December 11, 2025

**Re: U-Haul at 8200 Jefferson St. NE
Erosion and Sediment Control Plan – C17E146 – (SWQ-2025-00051)
Engineer’s Stamp Date: 12/3/25**

Based on the information in your submittal received on 12/3/25, the ESC Plan and Notice of Intent (NOI) cannot be approved until the following comments are addressed. This is the first look at an ESC Plan since it was missing from the first submittal. The ESC Plan required by the City consists of all the Storm Water Pollution Prevention Plan (SWPPP) Map requirements from the EPA’s Construction General Permit (CGP) Part 7.2.4. Additional items from the SWPPP are required on the ESC Plan by the city’s checklist sent with the first comment letter.

DRAWN:	GBV	
CHECKED:	ARA	CO-10
DATE:	12/03/25	
CO-TITLE

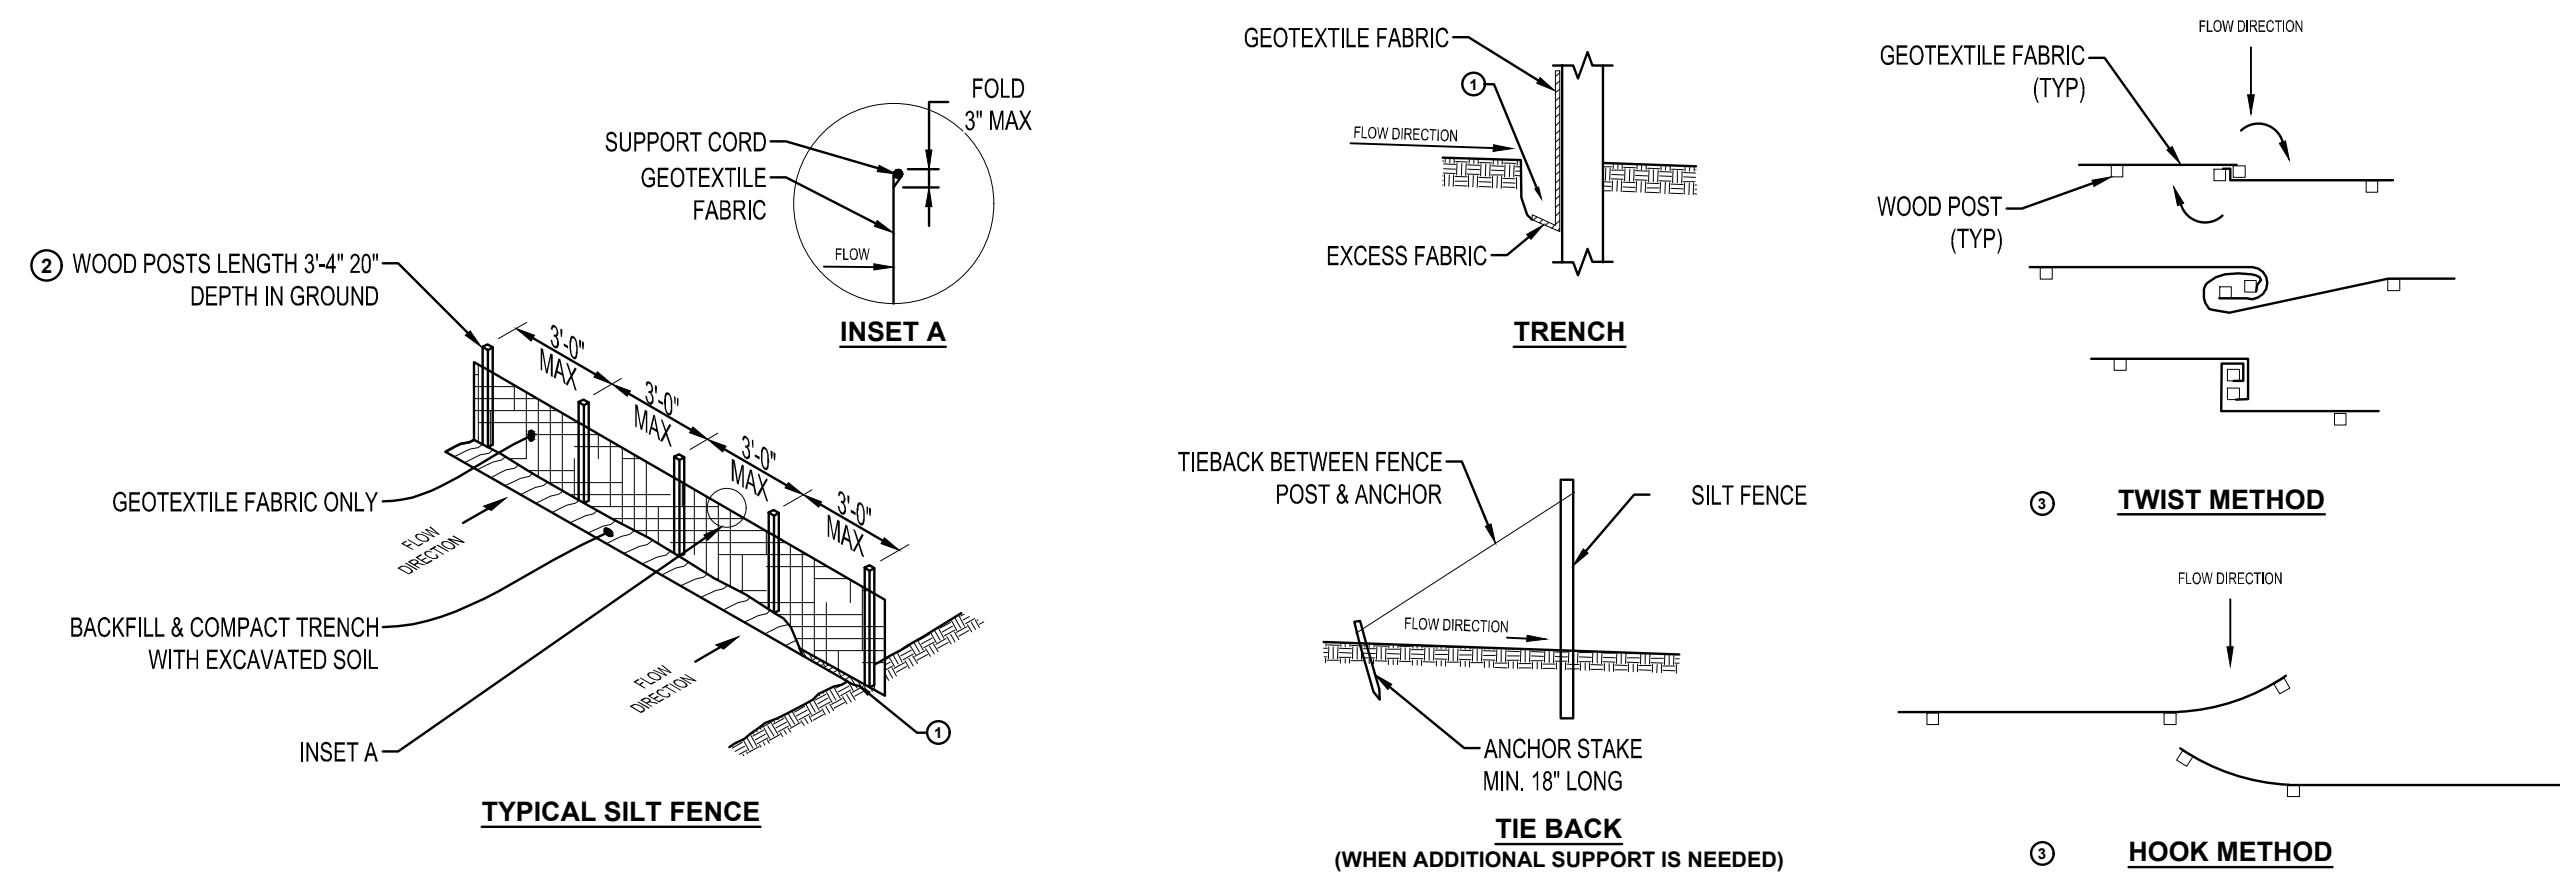
2. The cover page, Sheet C0-10, includes Site Data that doesn’t pertain to the Erosion and Sediment Control (ESC) Plan except that it has a vicinity map and a sheet index. Street names must be added to the vicinity map. The index lists four sheets pertaining to the SWPPP, but the SWPPP Notes, sheet C1-10, are missing from the plan set and may contain information required on the ESC Plan. The extraneous sheets must be removed from the ESC Plan index. The ESC Plan isn’t part of the Building Permit plan set; it is a separate, standalone plan that must be kept with the SWPPP during construction. The sheets should be numbered sequentially, for example: for a three-page set of plans, they would be numbered 1 of 3, 2 of 3, and 3 of 3.

DRAWN:	GBV
CHECKED:	ARA C1-20
DATE:

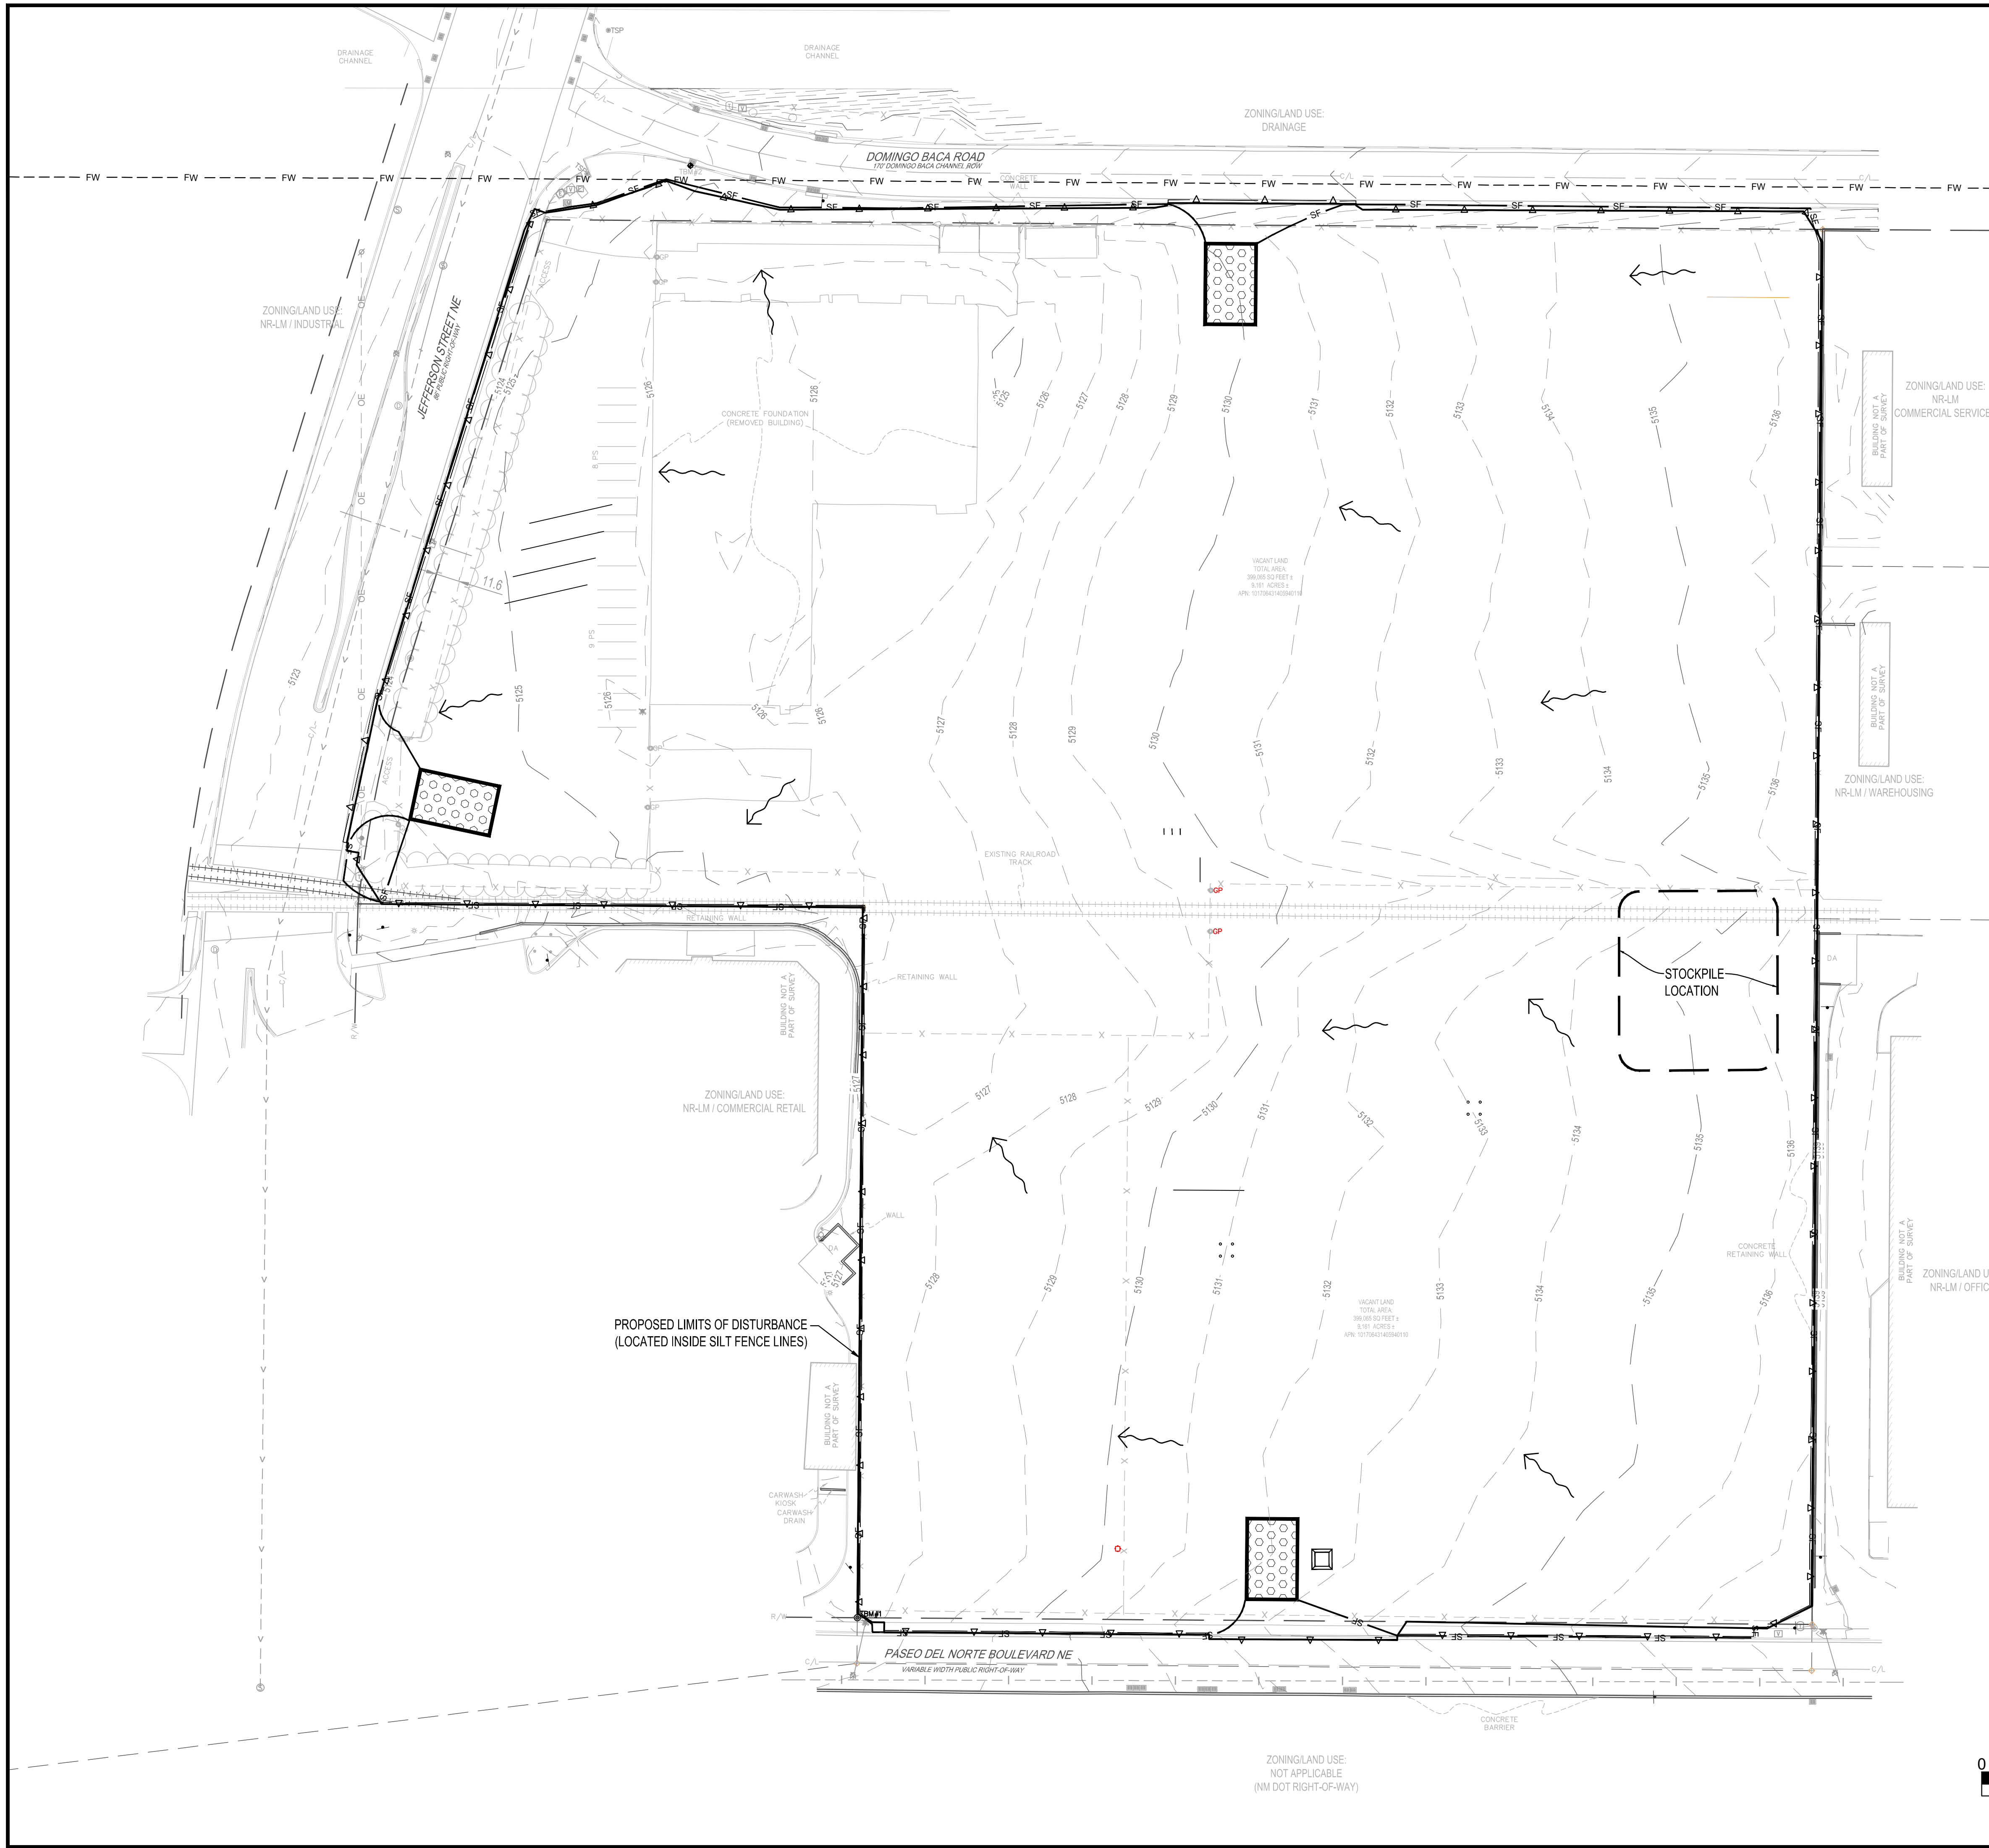
3. The BMP details on the SWPPP Details, sheet C1-20, are substandard because they are missing the design specifications, maintenance schedules, and criteria for inspections as required by CGP 9.4.1.c.i. You must *“design and install all stormwater controls in accordance with good engineering practices, including applicable design specifications”* per CGP 2.1.3. Please replace the BMP details in the ESC Plan with standard details that include design specifications, construction specifications, maintenance schedules, and inspection criteria.

DRAWN:	GBV
CHECKED:	ARA C1-40
DATE:	12/03/25

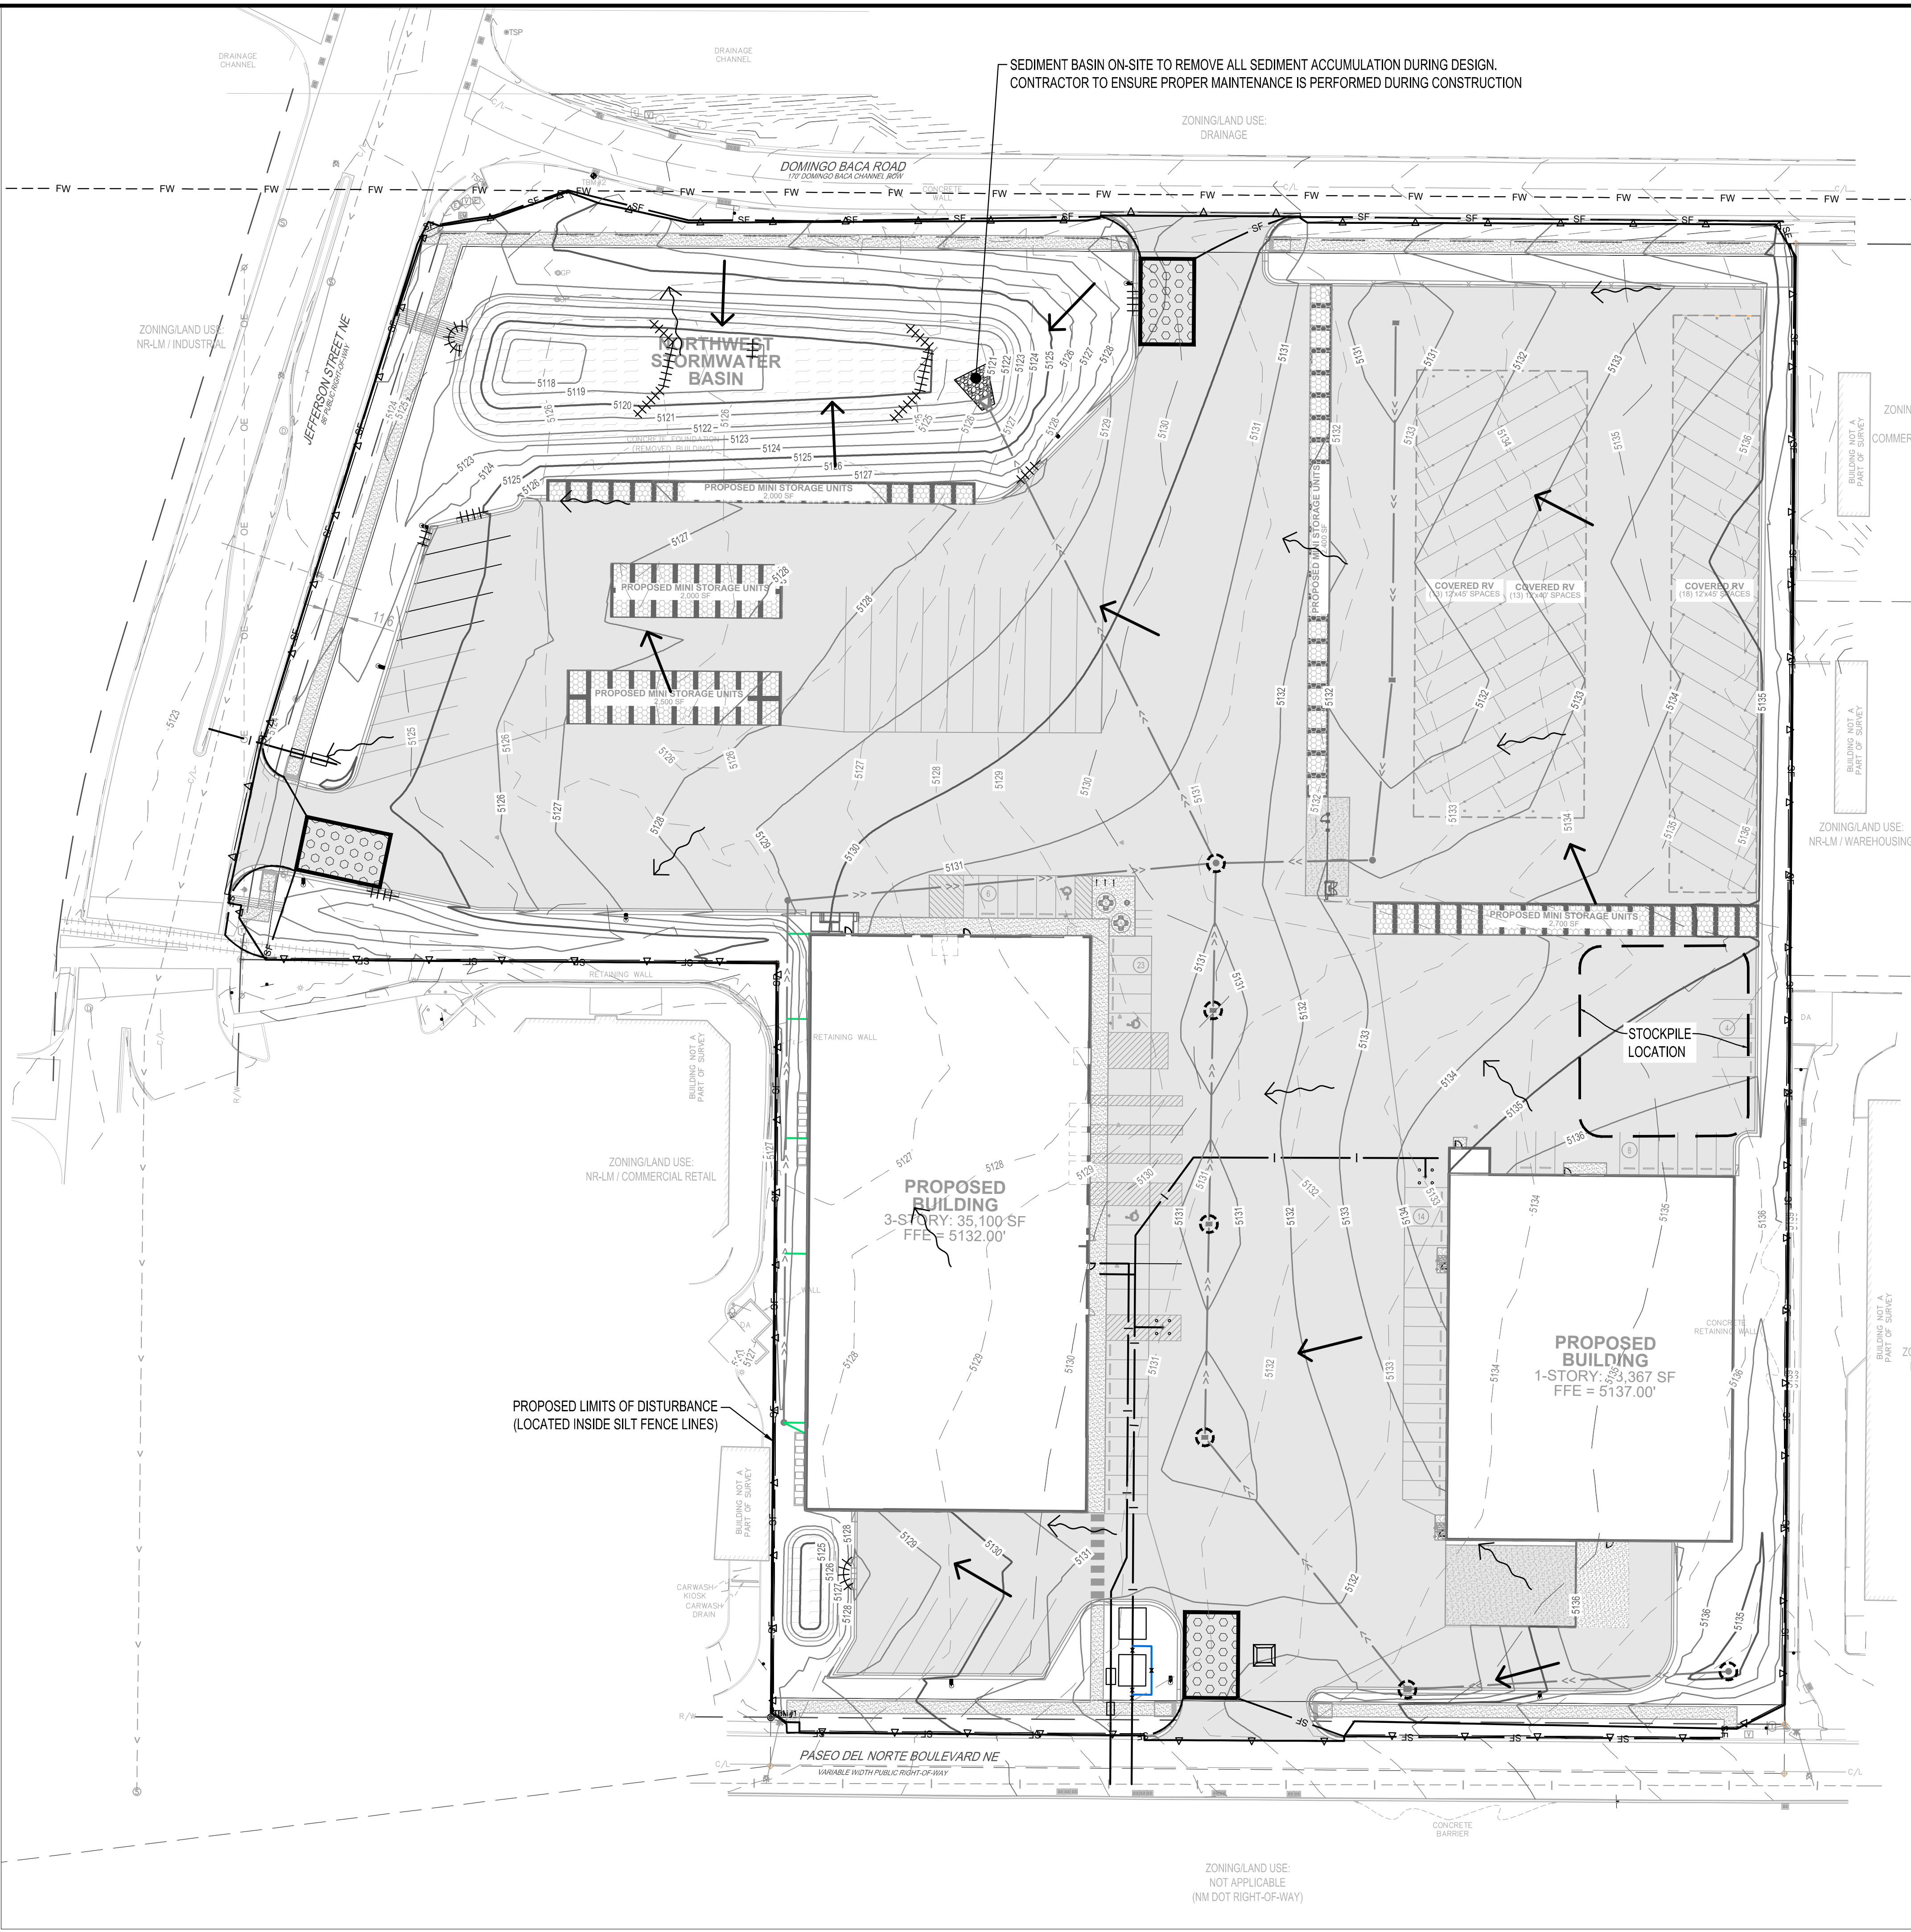
4. Sheets C1-30 and C1-40 have a note at the bottom of the ESC Plan Check List that says, *“sediment basin: drainage basin shall provide the calculated volume of 3,600 cf per acre of drainage area. 8.54 ac drainage area and requires 30,744 cf (31,724 cf provided in northwest detention basin).”* The post-construction pond probably has the temporary volume required for the worst-case scenario during construction, but the calculations are inaccurate and incomplete. A temporary conveyance system must also be designed because most of the site doesn’t naturally drain to the pond. The NMED requirements in CGP 9.6.1.c.i state: *“The SWPPP must identify and document the rationale for selecting these BMPs and/or other controls. The SWPPP must also describe design specifications, construction specifications, maintenance schedules (including a long-term maintenance plan), criteria for inspections, and expected performance and longevity of these BMPs. For sites greater than 5 acres in size “BMP selection must be made based on the use of appropriate soil loss prediction models or equivalent generally accepted soil loss prediction tools,”* and part 9.6.1.c.iii states: *“All SWPPPs must be prepared in accordance with good engineering practices by qualified (e.g., CPESC certified, engineers with appropriate training) erosion control specialists familiar with the use of soil loss prediction models and design of erosion and sediment control systems based on these models.”* Documentation is required on the ESC Plan. Include soil information – add a table with name type, particle sizes, and Erodibility factor per CGP 2.1.1. Also identify and document the rationale for selecting these BMPs and/or other controls per CGP 9.6.1.c.i. Add a narrative description and soil-loss calculations to the ESC Plan.

5. The stormwater controls are inadequate. Silt Fences (SF) on sheets C1-30 and C1-40 are not effective stormwater controls for the large drainage areas and concentrated flows on this site, although they are still necessary for fugitive dust control. Diversion Channels (DC) and Sediment Traps (ST) are required along the west edge of the area of land disturbing activity and must be included with the stormwater controls installed as the initial construction items. The Construction Exit (CE) on the west side of the site conflicts with the need for a Diversion Channel (DC) on the same side to direct stormwater to the large ST in the northwest corner. Therefore, the CE should be removed from the ESC Plan, and design calculations for the DC and ST must be added to the plan. Consider installing an interim DC along the low side of the new storm drains as the first step in construction to control stormwater until the storm drains are built. Also, consider adding a retaining wall at the west property line next to the new building as support for a DC. Include a cross-section of the DC on the west side of the building. The ESC Plan must specify how and when stormwater will be directed into the ST(s). Additional STs may be required. Follow the design specifications and ESC Plan requirements outlined in the attached draft DC and ST details or equivalent details.
